From: Charlie Craddock - Elite Nugen [REDACTED]
Sent: 26 November 2021 14:12
To: Iqraa Malik
Subject: RE: Planning submission -PP-10337757
Attachments: We sent you safe versions of your files; 1701_005-Existing First Floor Plan-R.pdf; 1701_202-Proposed First Floor Plan-R.pdf

Confirming Aggreed Description : "Erection of single storey side extension."

White Lodge
Rectory Lane

Angmering
Bn16 4ju

First Floor Plan
as existing

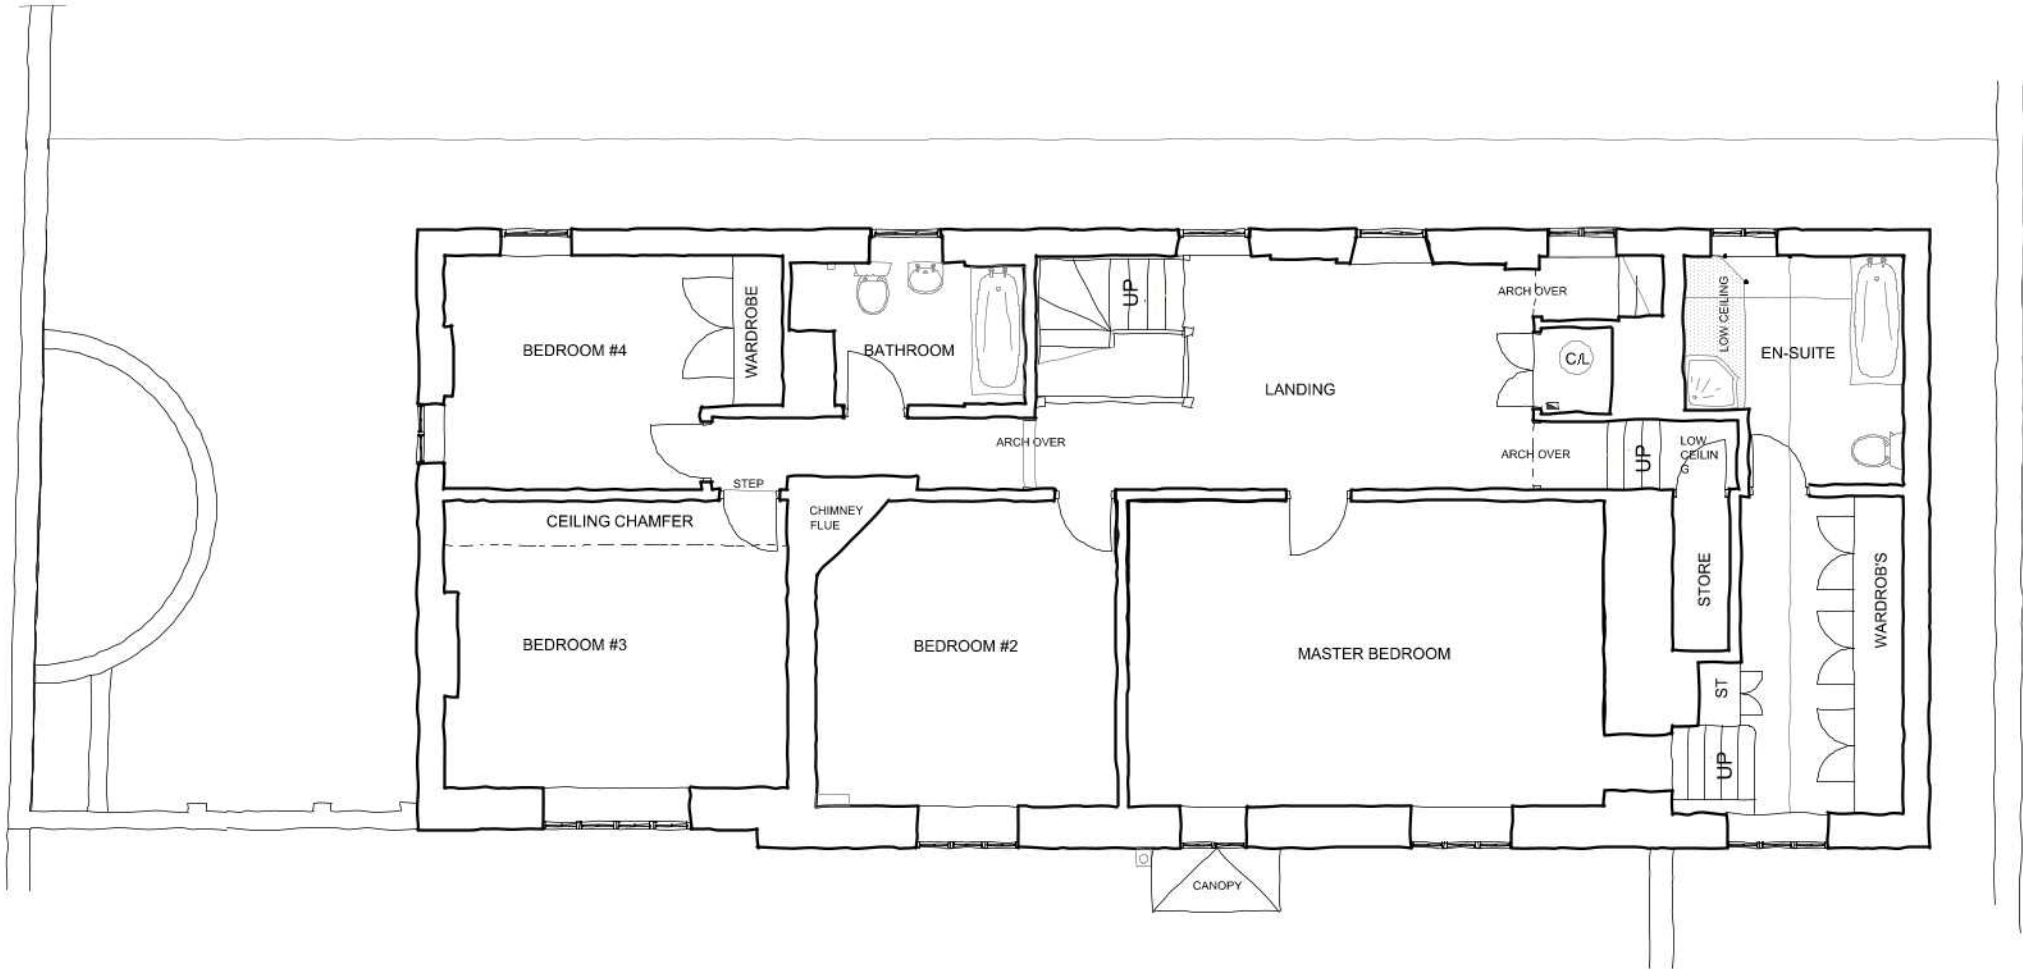
As you have answered no to both questions 4, this means questions 5-7 can be skipped. Please amend. Along with this, the windows are inconsistent between the existing/proposed first floor plans and the existing/proposed rear elevations. Please review and amend.

Plans: The windows are inconsistent between the existing/proposed first floor plans and the existing/proposed rear elevations. Please amend.

Plans: The windows are inconsistent between the existing/proposed first floor plans and the existing/proposed rear elevations. Please amend.

The amended revised plans, please confirm these are acceptable and I will upload to the portal
Many thanks
Regards
Charlie
